**RE: DRB Approval of EPC approved
Site Plan for Building Permit 13EPC40097
Site Plan for Subdivision 13EPC40099
Project # 1009600**

Rio Grande Engineering requests approval of the enclosed site plans for subdivision and Building permit. The proposed development will be a two phased twenty four unit townhome apartment project located at the southwest corner of Alice and Cardenas NE. The following is a summary of the conditions of approval and a response as to how they were addressed:

Project# 1009600
13EPC-40097 Site Development Plan for Building
Permit
13EPC-40098 Zone Map Amendment (Zone
Change)
13EPC-40099 Site Development Plan for
Subdivision

DRAWING TITLE: SITE LANDSCAPE PLAN

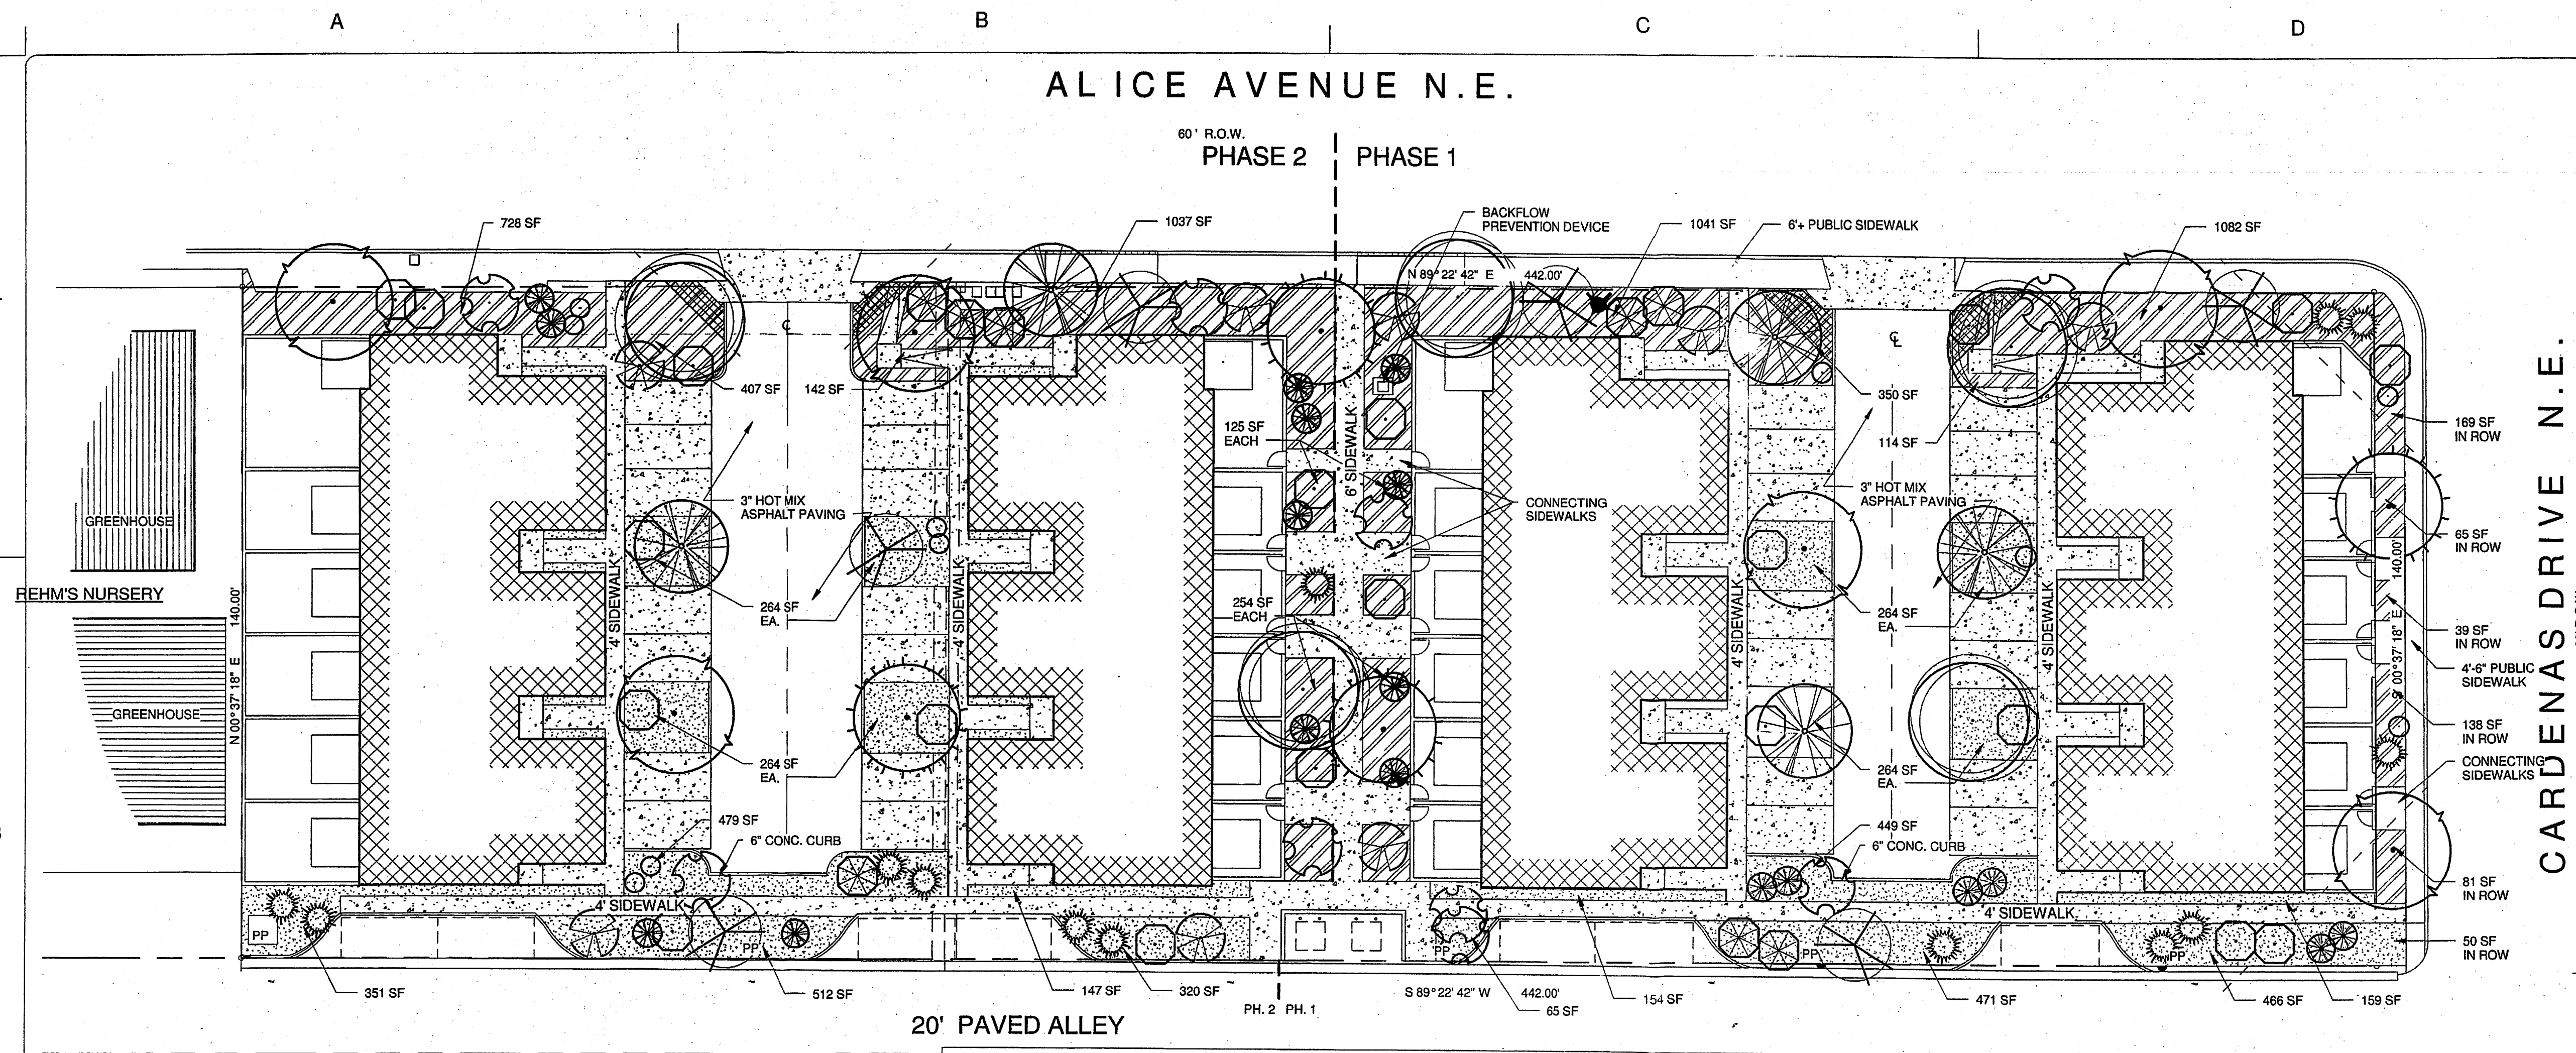
- d. Add not to landscape plan regarding clear site triangle

This note has been added to the Mylar, the paper copies were made prior to addition, the Mylar will be presented at DRB.
